WEST SUSSEX COUNTY COUNCIL CONSULTATION

TO:	Arun District Council FAO:Mr S Davis
FROM:	WSCC - Highways Authority
DATE:	21 May 2019
LOCATION:	The Cottage Shripney Road Bognor Regis PO22 9PA
SUBJECT:	BE/58/19/RES Application for approval of reserved matters following outline permission BE/63/17/OUT & variation of condition BE/131/18/PL for replacement dwelling at the southern end of site (Phase 1).
DATE OF SITE VISIT:	N/A
RECOMMENDATION:	No Objection
S106 CONTRIBUTION TOTAL:	£N/A

SITE PLAN

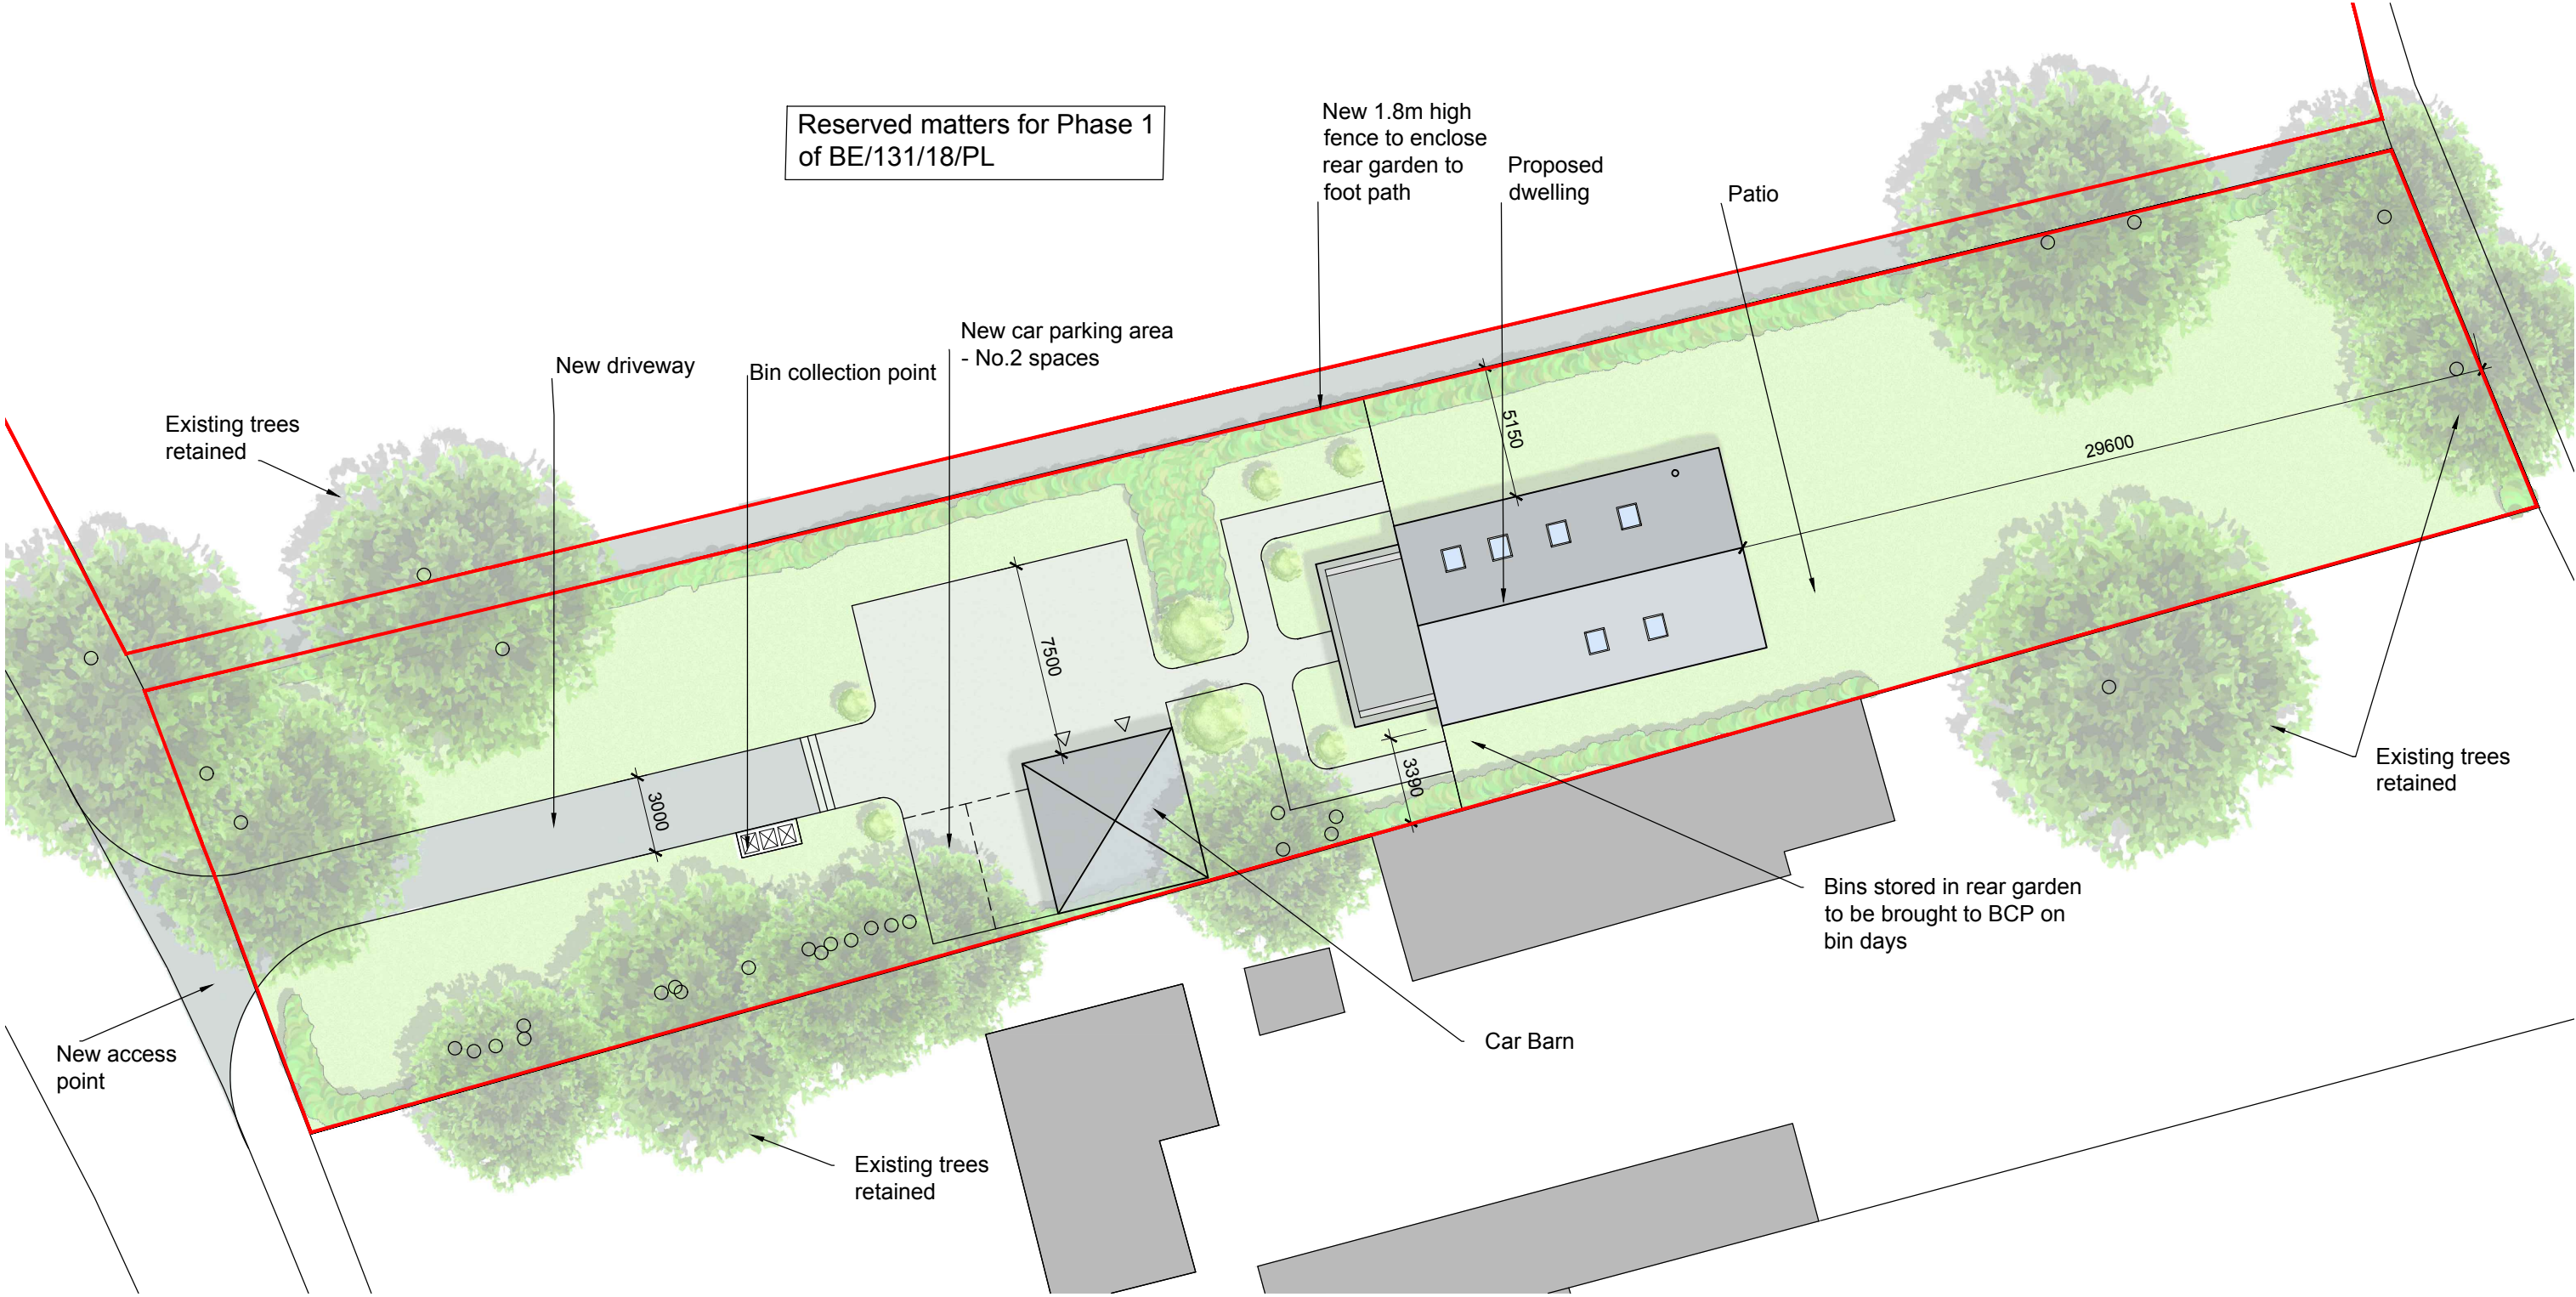
The proposed site plan (drawing no: 004 Rev D) states a 'New Access point'. However it is assumed this is an error and the access will remain in the same position as the existing access under the previous planning consent and will just be upgraded to a cross over point from the highway constructed to WSCC standards? If this is the case then the LHA would raise no concern to this application.

If the location of the access is changing and this is a new access point then further information will be required to support the relocation and any effect this may have on the neighbouring access points.

Subject to the access remaining in exactly the same position the LHA would raise no concerns. If gates are being installed these should be set back from the highway to allow a vehicle entering the site to wait clear of the highway, while they are being operated. Also no boundary treatment above 600mm should be installed at the access point to obstruct pedestrian visibility and the visibility of a vehicle leaving the site to see pedestrians. The following informative and conditions should be added to any grant of planning consent.
